Application by Thurrock Power Ltd for an Order Granting Development Consent for the Thurrock Flexible Generation Plant Project

Response to Procedural Deadline D

Specialist Archaeological Advice

20/00273/DCO Thurrock Flexible Generation Plant, Fort Road, Tilbury

Figure 13

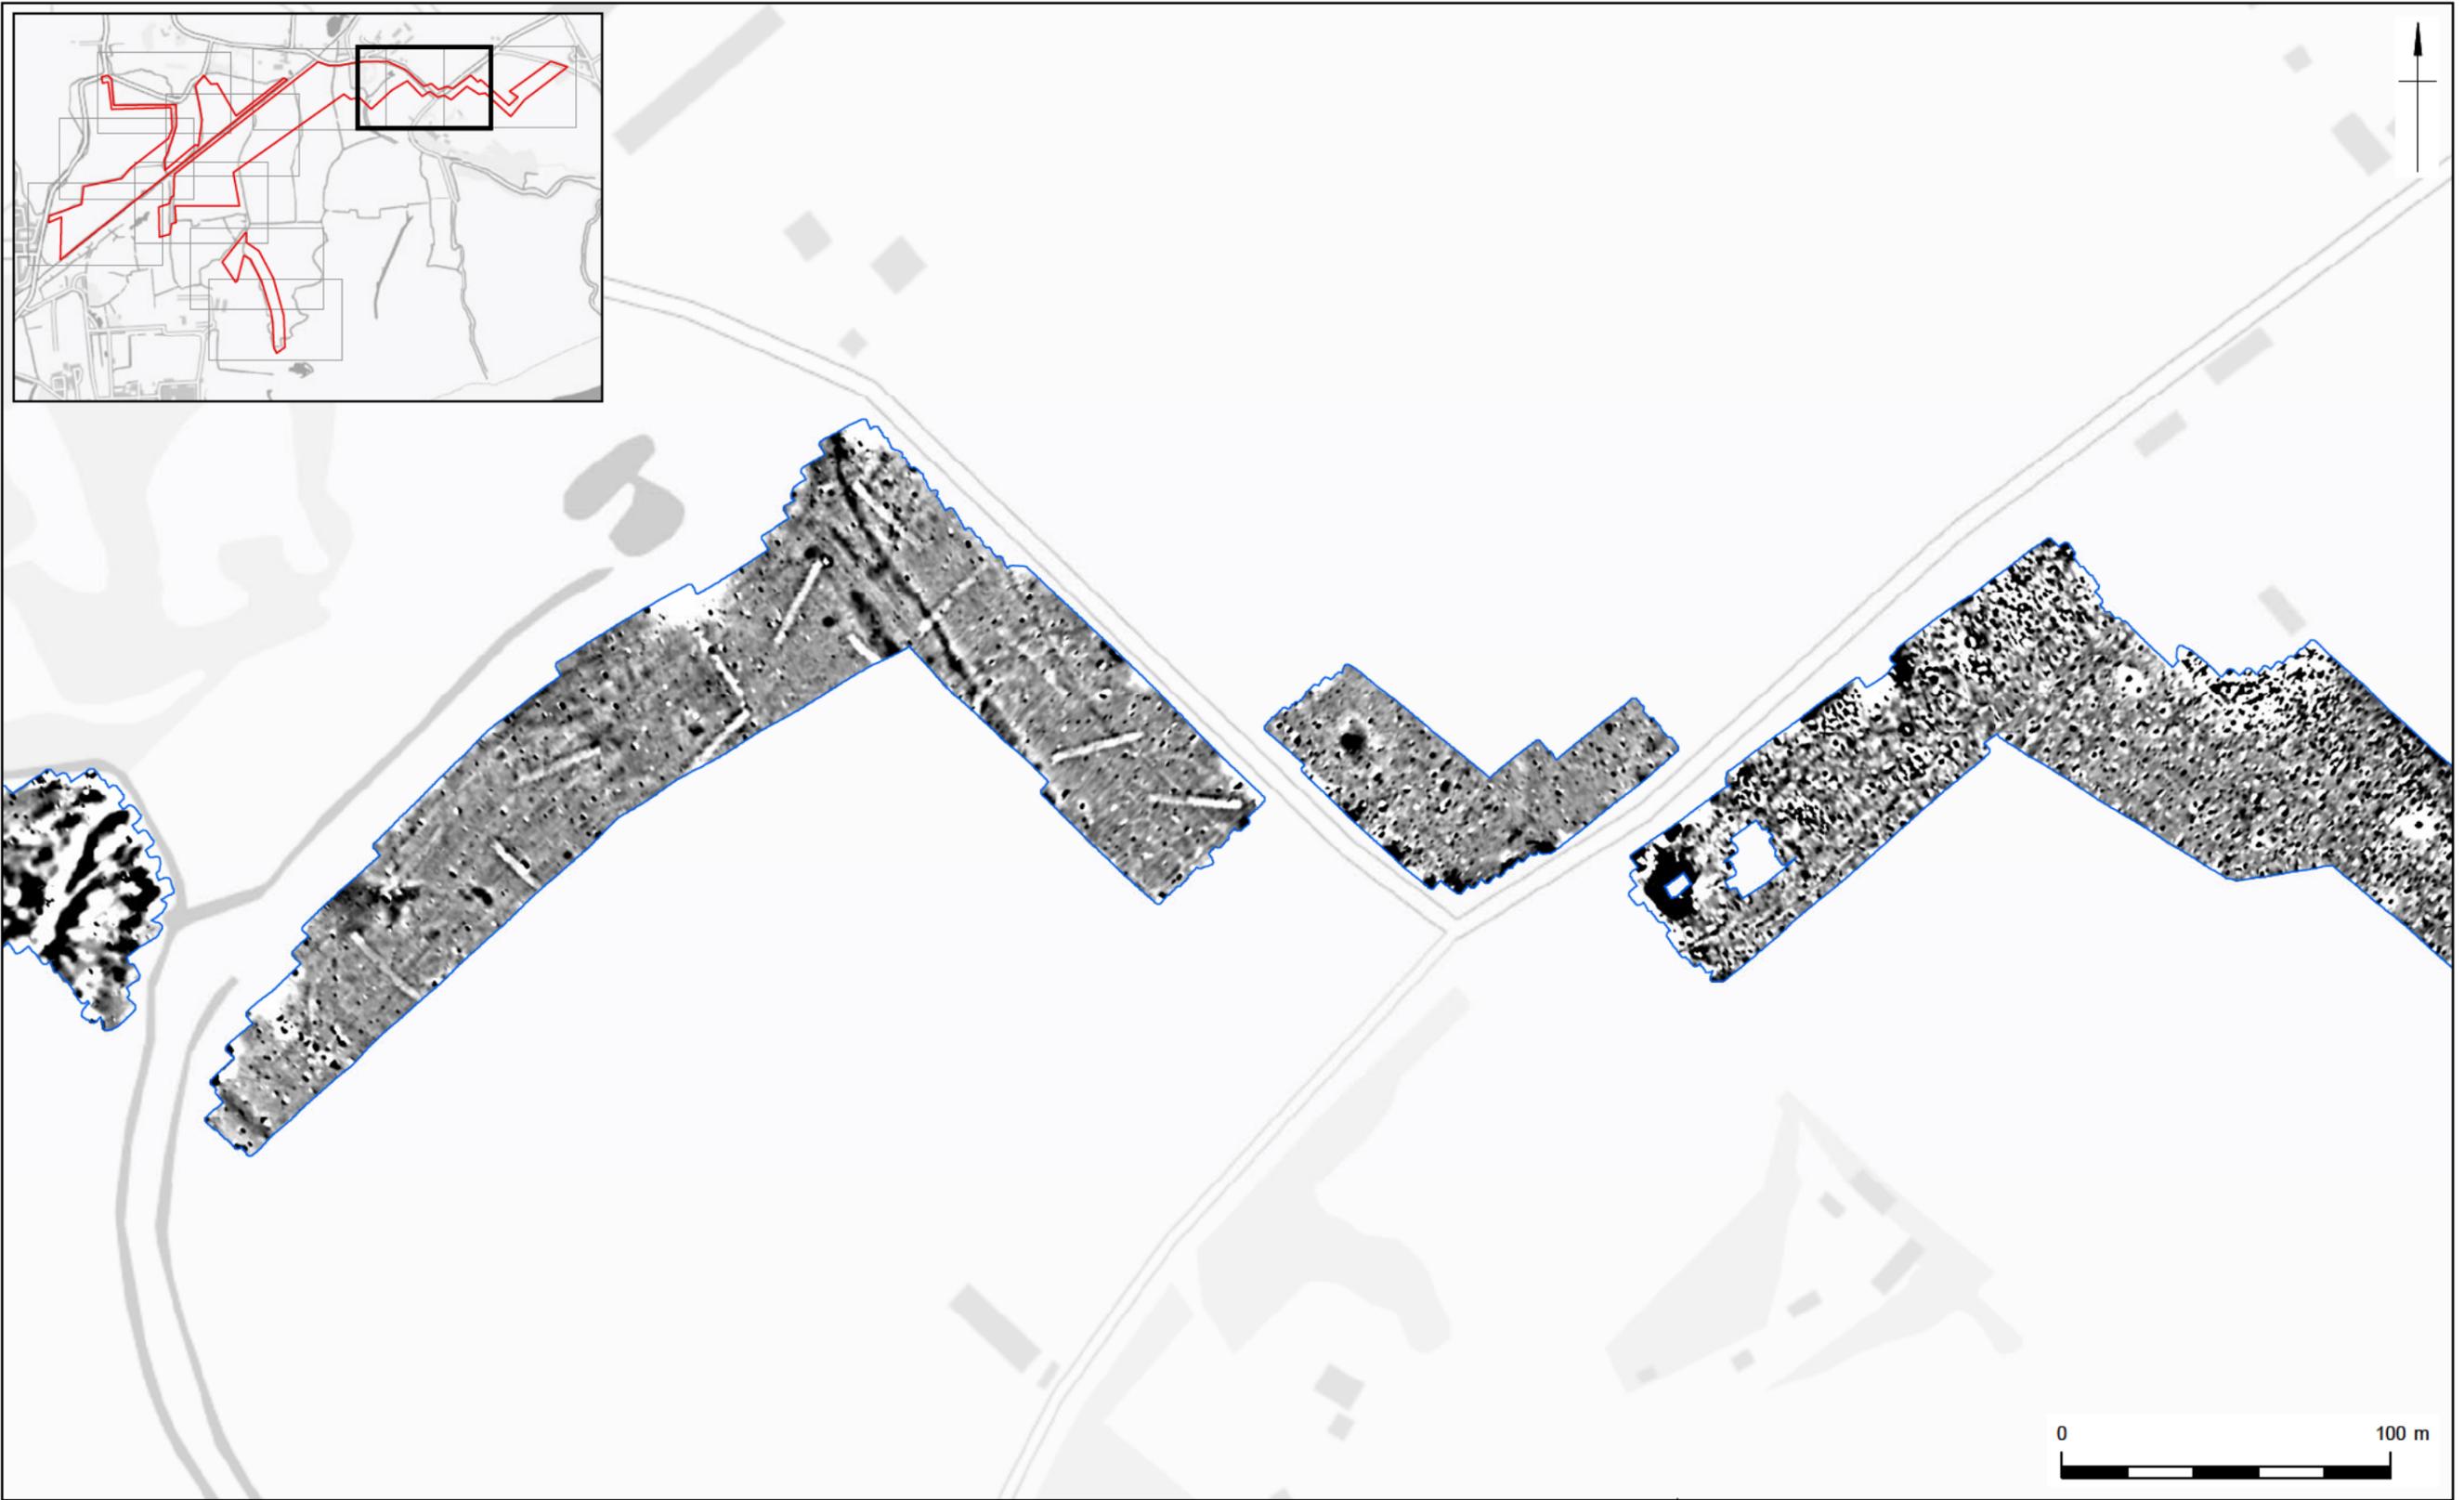
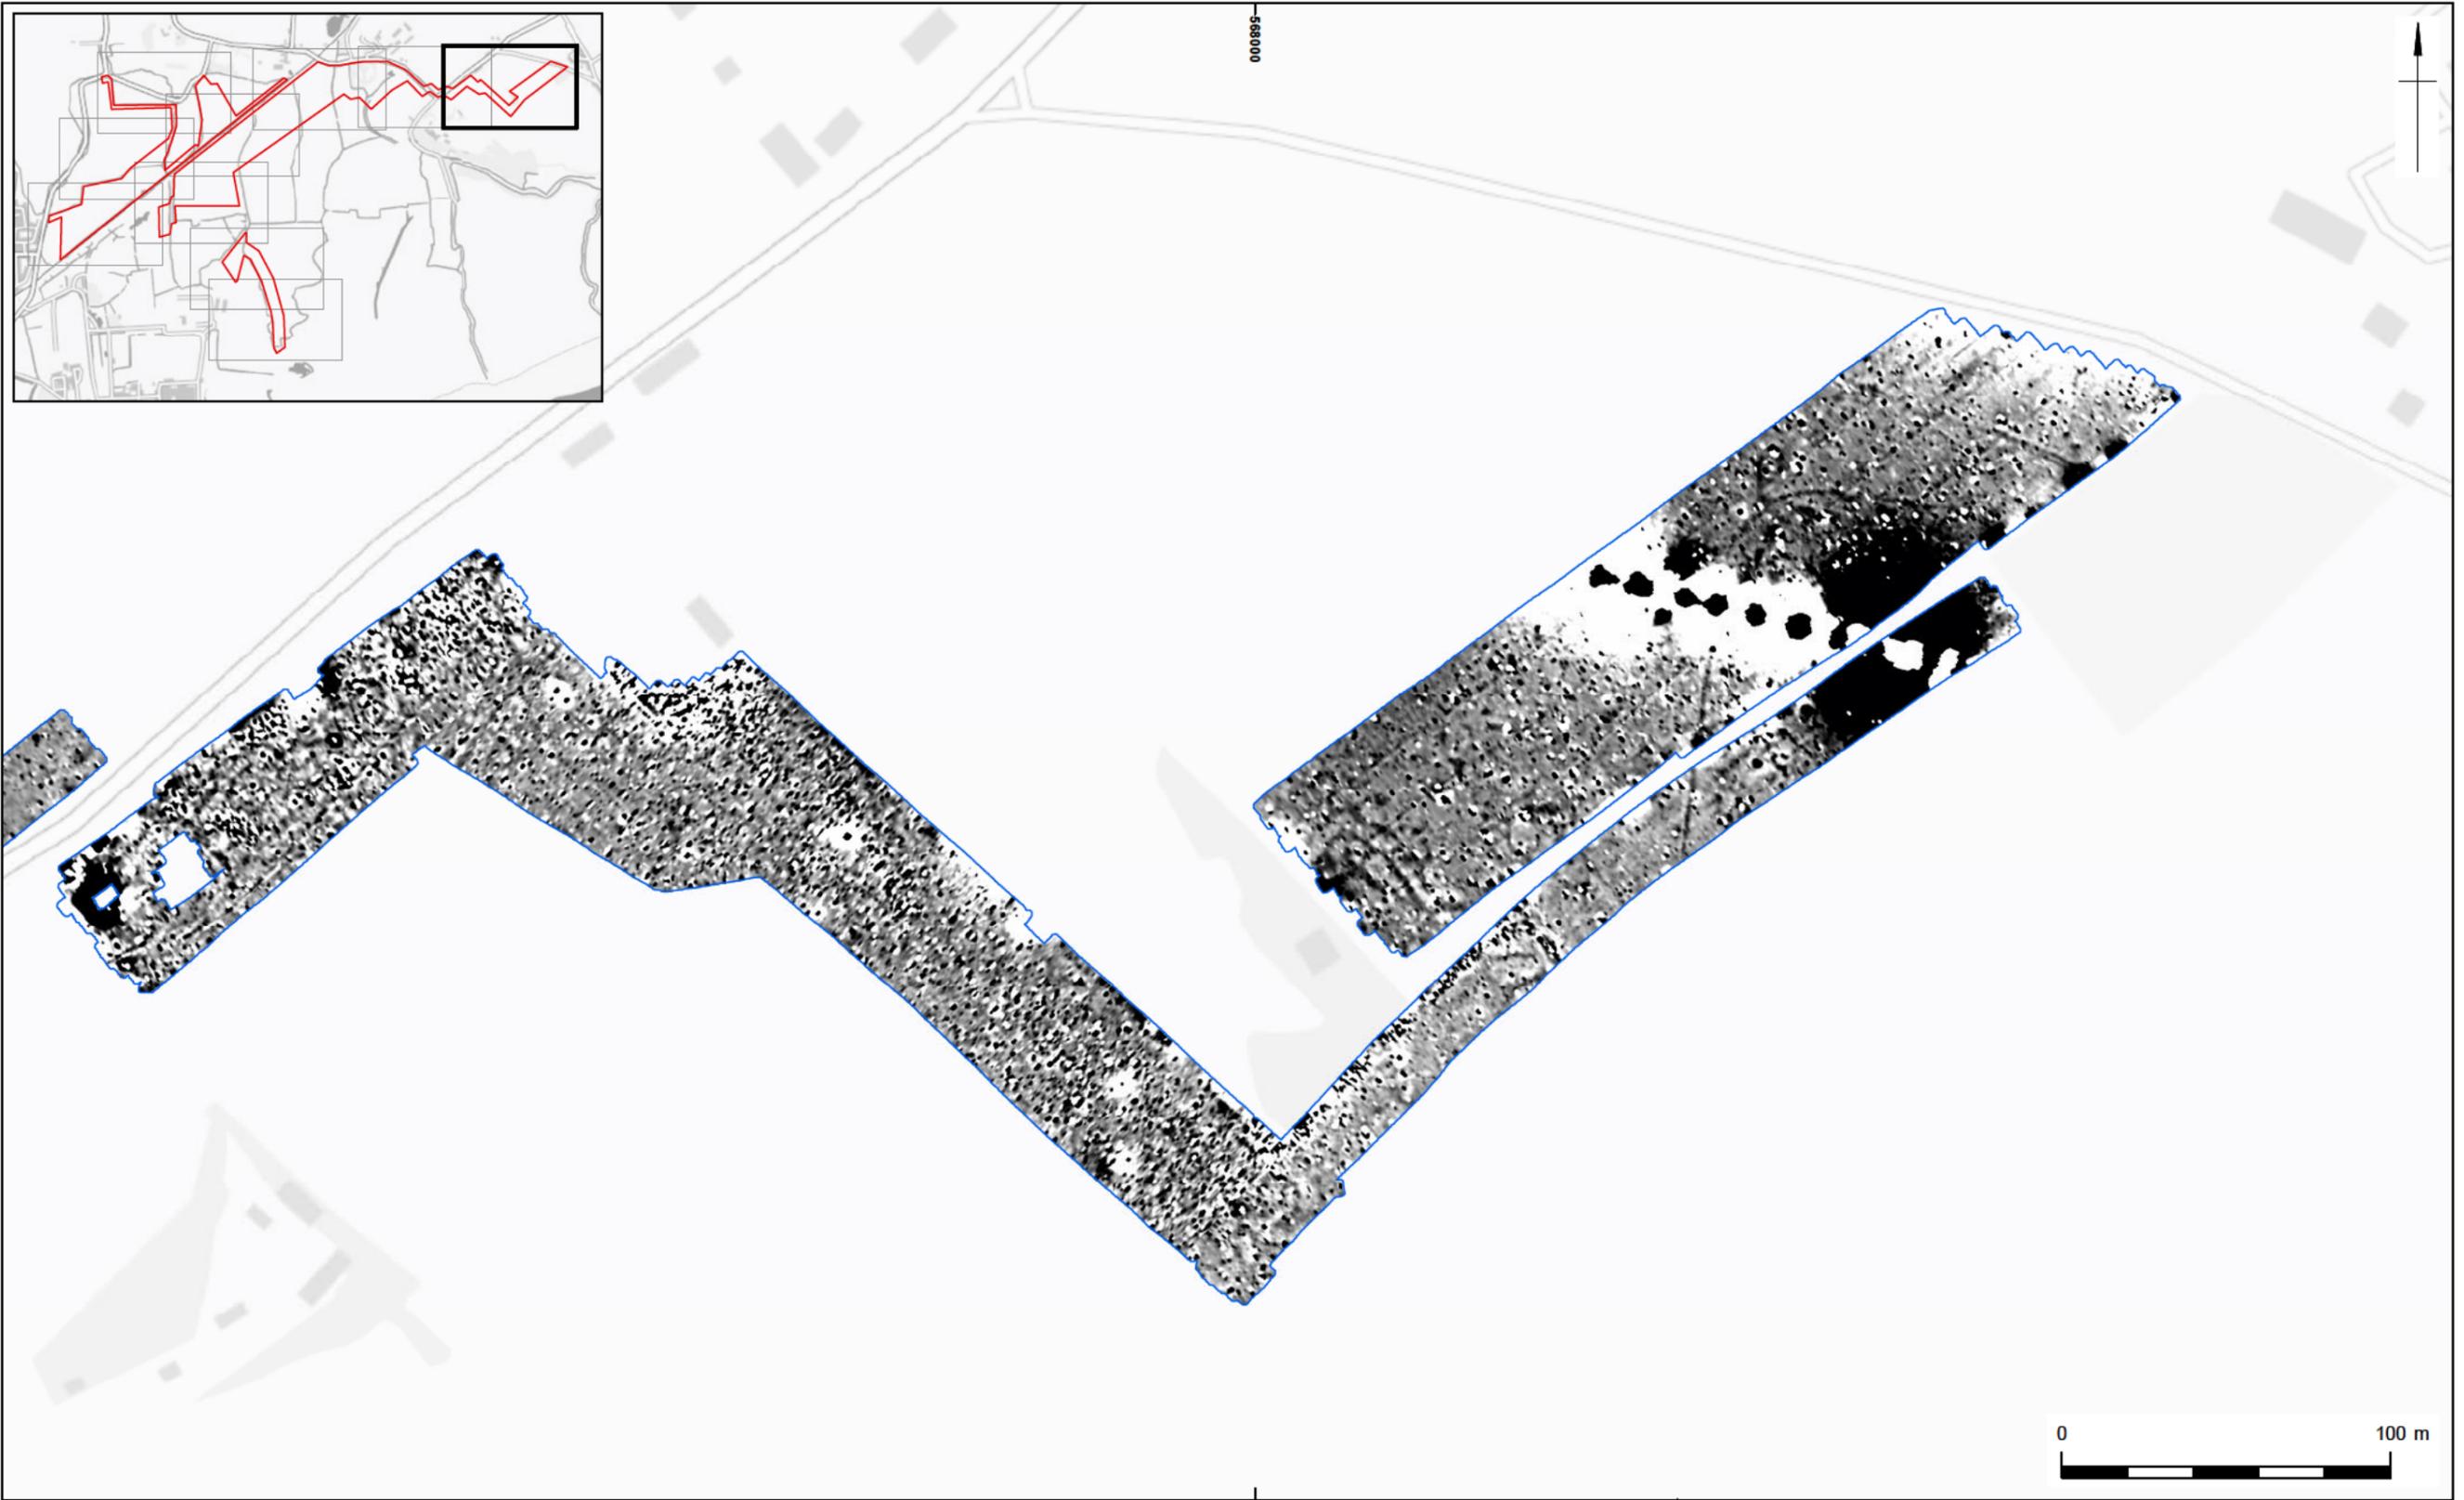
It is pleasing to see that in the documents provided in December that geophysical surveys have been undertaken on the majority of the development area. This provides basic data which can be built on to facilitate an understanding of the historic environment so that the inspector can make an informed decision on the impact of the development. It is disappointing that the applicant does not have the detailed results of the geophysics as the present document provides little detail on the results.

These results also need to be ground truthed to have an understanding as to what the features represent. Large scale developments in the area have shown extensive red hill (saltern) complexes surviving within the grazing marsh area. Similarly, the Lower Thames trial trenching, being undertaken to support their DCO submission has shown an extensive archaeological site of Roman date at the eastern end of this application.
